From: Steph Mifflin
Sent: Monday, November 17, 2025 11:55 AM
To: Ellie Myers; Jeremy Larson
Subject: RE: SP-25-00011 Hubbard - Notice of Application

Please review the following Short Plat application: SP-25-00011 Hubbard. Any comments need to be received by **5 PM on November 17, 2025**.

TO: All Staff
FROM: Public Works Plan Review Team
DATE: November 13, 2025
SUBJECT: SP-25-00011 Hubbard

HUBBARD SHORT PLAT
PART OF SECTION 6, T. 17 N., R. 20 E., W.M.
KITTITAS COUNTY, WASHINGTON

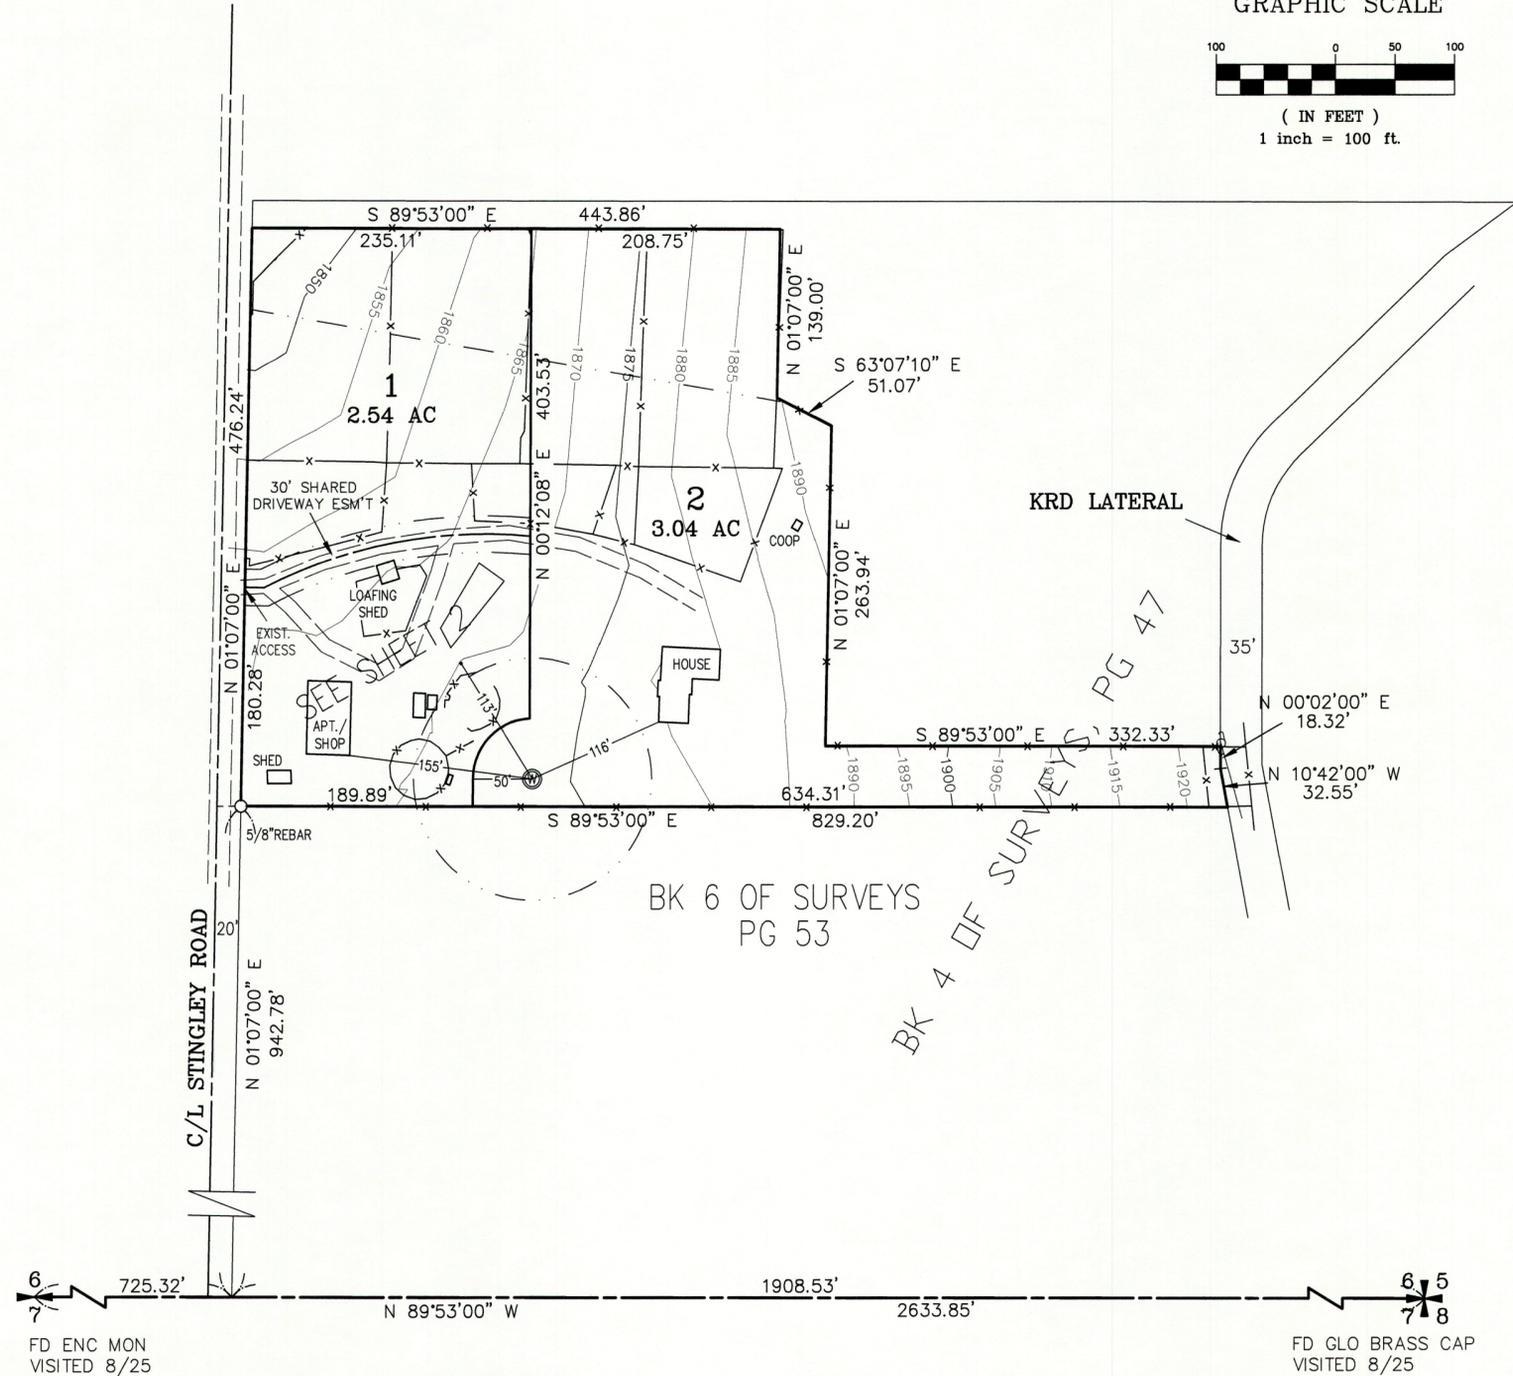
Building records indicate that the structure labeled as APT./SHOP has never obtained a building permit to convert any portion of the permitted shop into a residential dwelling or habitable space. The owner will need to go through the permitting process and obtain a *Change of Use* building permit for the conversion of the shop.

HUBBARD SHORT PLAT PART OF SECTION 6, T. 17 N., R. 20 E., W.M. KITITAS COUNTY, WASHINGTON

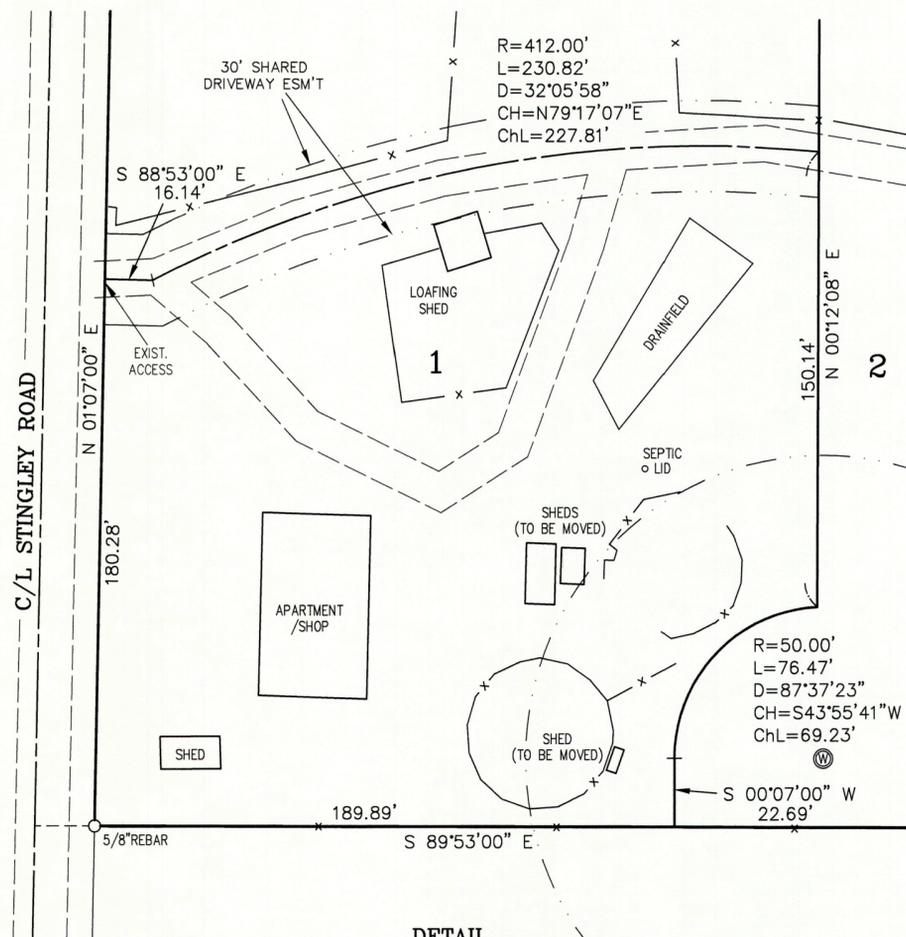
SURVEY	<ol style="list-style-type: none"> 1. Basis of bearings needs to be called out. 2. Recording number for Driveway easement – Existing or proposed? 3. Notes 1 and 2 on page 2 are overlapping. <p>(DF)</p>
TRANSPORTATION CONCURRENCY	<p>No transportation concurrency requirement for this project. (RC)</p>
FLOOD	<p>Parcel #200533 is not within the FEMA identified special flood hazard area (100-year floodplain). A floodplain development permit is not required for the project. (SC)</p>
